**ADC Planning Consultation
Conservation/Design Officer Response**

Application Number	BR/252/17/L
Address	The Royal Norfolk Hotel The Esplanade Bognor Regis PO21 2LH
Description	Application for listed building consent for internal alteration works to create additional bedrooms
Case Officer	<u>Mr S Davis</u>
Date	29 th November 2017

Client : Royal Norfolk Hotel - Bognor
Date : 20.07.17
Title : Ground floor layout
Scale : 1:100 @ A1
Drawn : AC

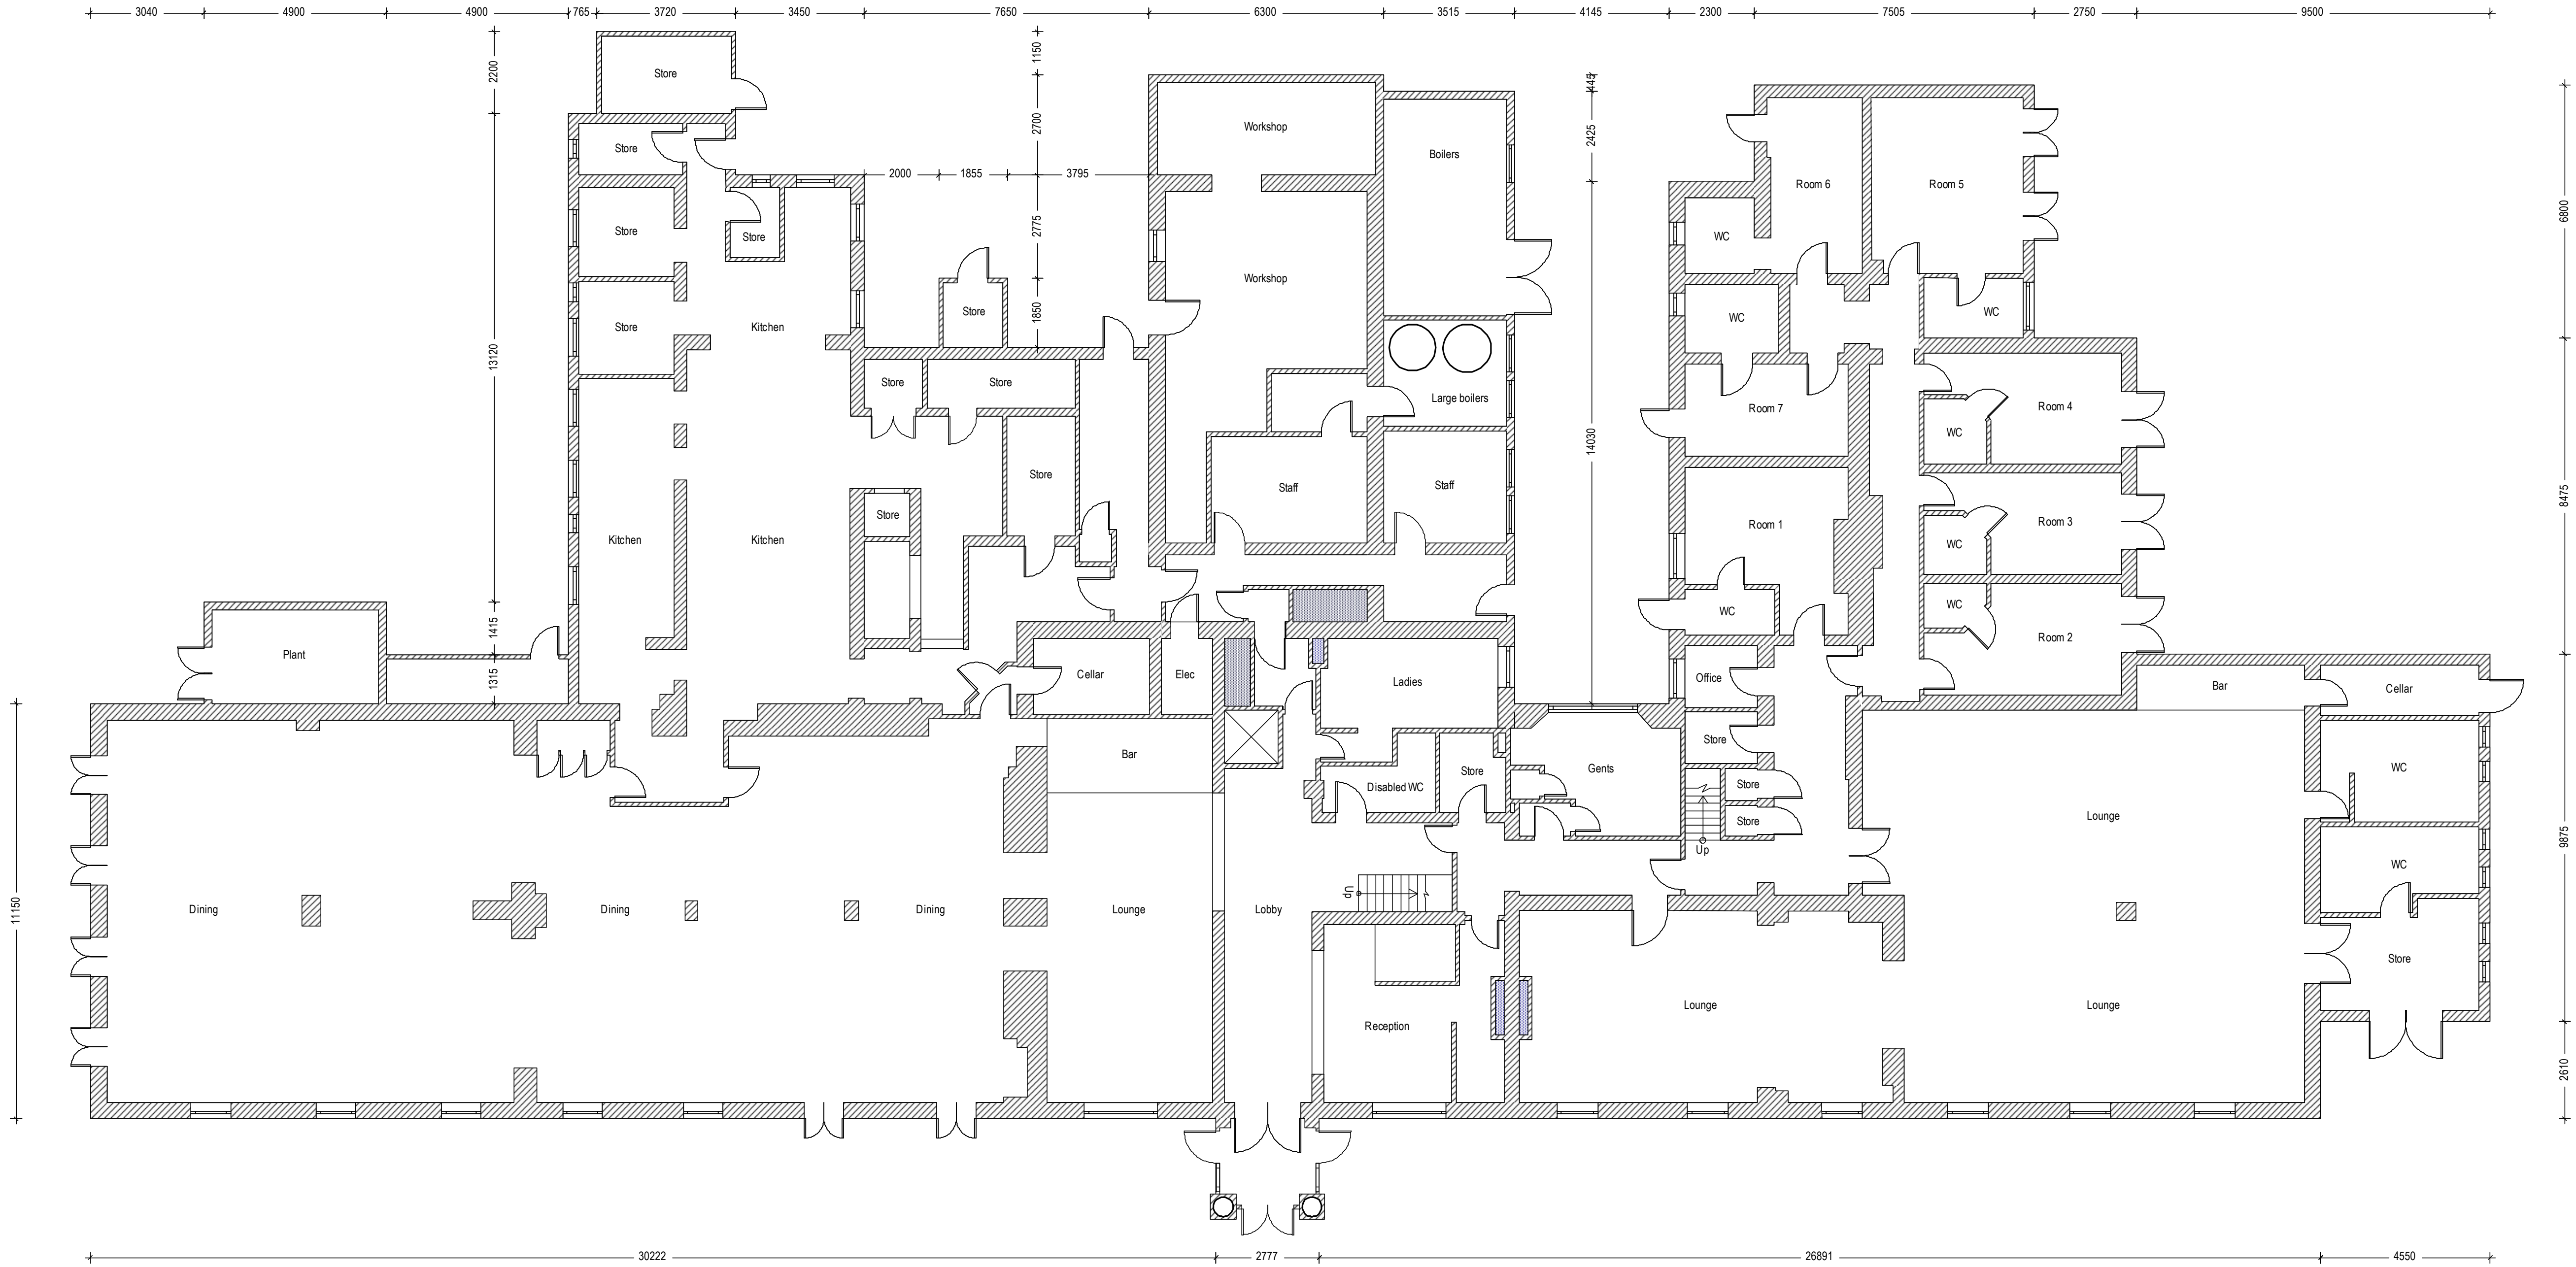
The proposed works are to reconfigure rooms to create extra bedrooms and en-suite facilities by realigning stud walling. The proposed locations pose no alteration to the exterior appearance of the hotel with the exception of 1no. window to be converted to a door on ground floor level. This new door should be timber, painted to match the blue of the existing fenestration.
